Application No: AW/281/21/HH
Site Address: 5 The Courtyard Fish Lane Aldwick PO21 3AJ
Description of works: Garage conversion to habitable use and loft conversion with 1 x dormer

Thank you for your internet representation made on 15th September 2021 which has been recorded as an objection with the comments as follows:

extending homes Tel:- 01243 555208 enquiries@extendinghomes.co.uk	
TITLE:- Loft and Garage Conversion @ 5 The Courtyard Fish Lane West Sussex PO21 3AJ	
DATE:-	10th May 2021
SCALE:-	Elevations Scale 1-100 on A1 Paper
DRAWN:-	P.Robinson
DWG. No. 2021053/PL/1

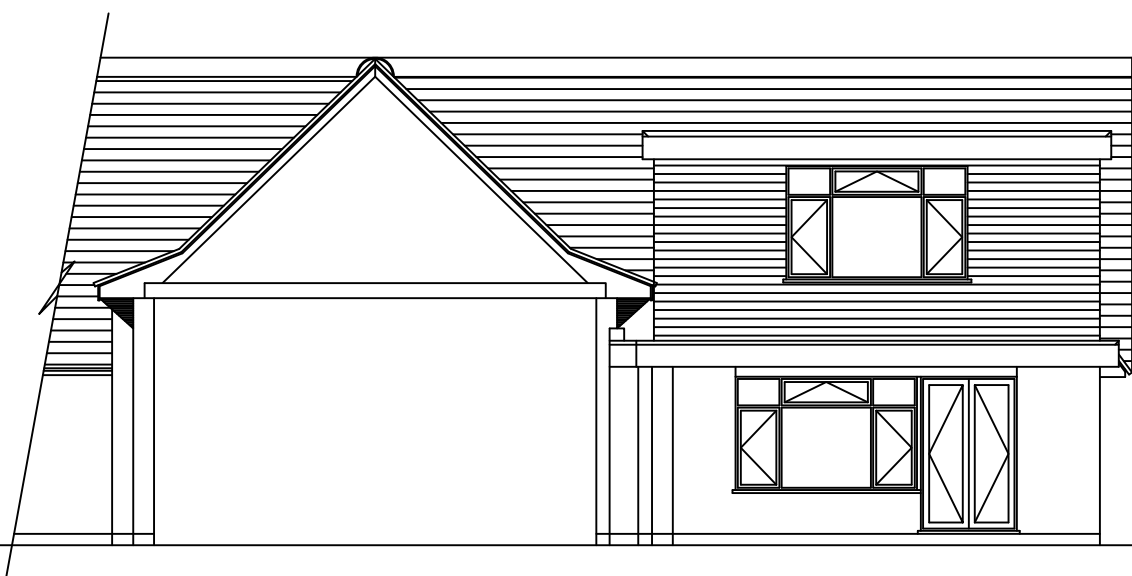
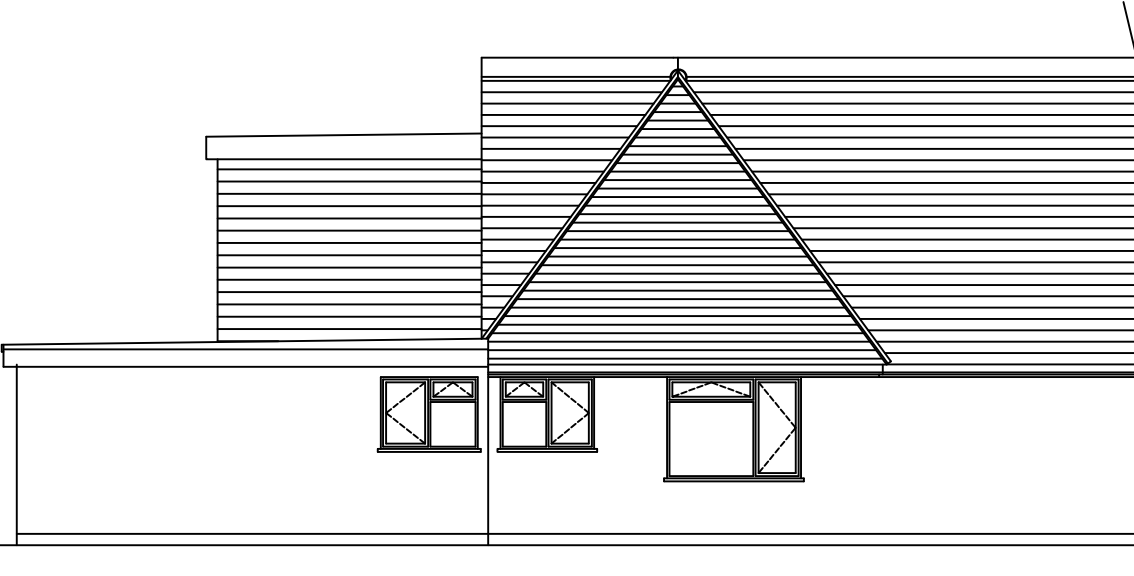
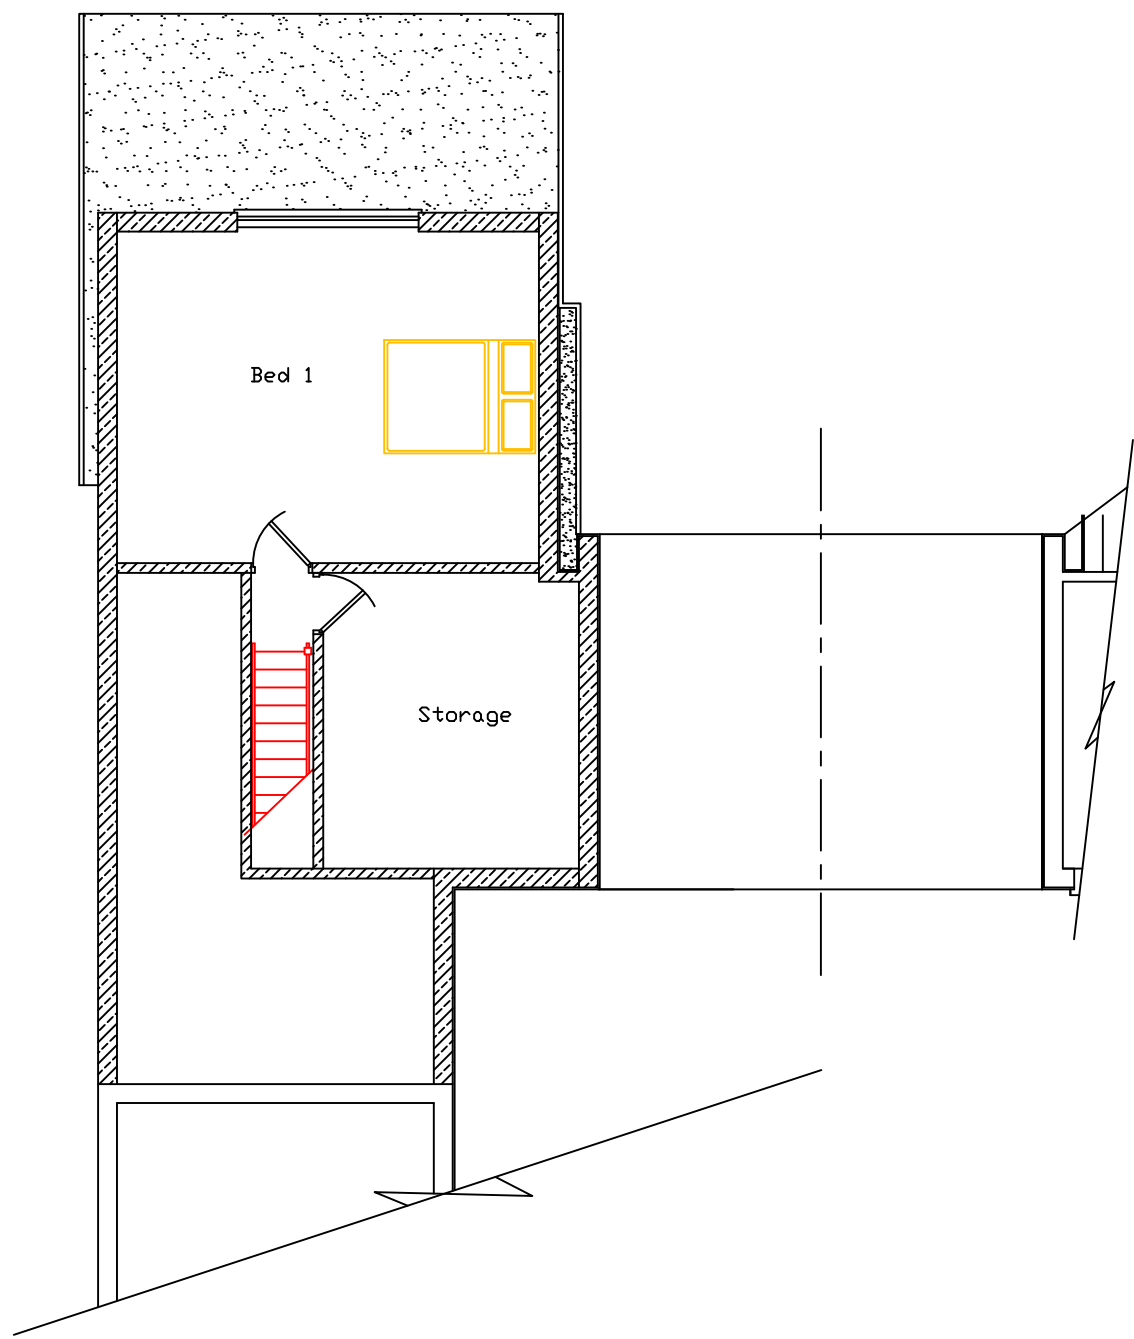
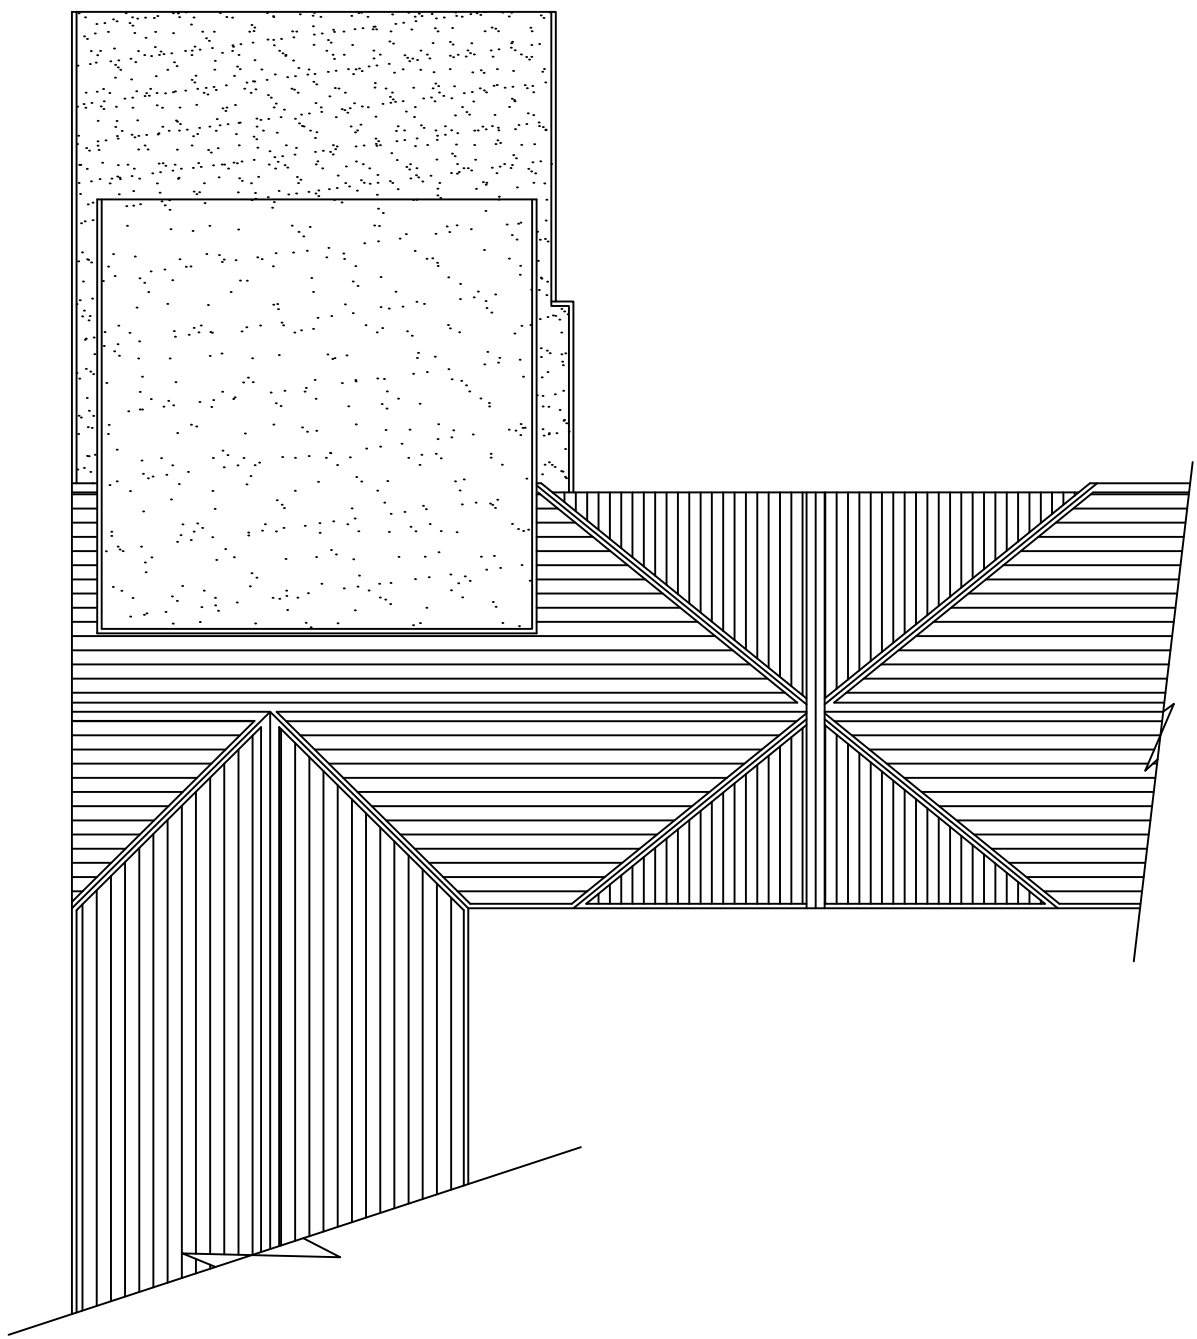
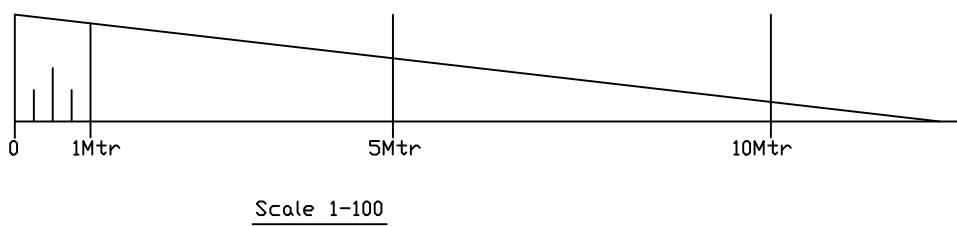
Members strongly objected to the application on the grounds that the extension is within an area of buildings of special character and because the proposed extension is not visually subservient to the main building; and because the alteration Compromises the established spatial character and pattern of the place.

Therefore, Members agreed that the application is in direct opposition to Policy D DM

4 (b) and (e) of the Arun Local Plan 2011-2021 and with the Parish Design Statement
Page 67.
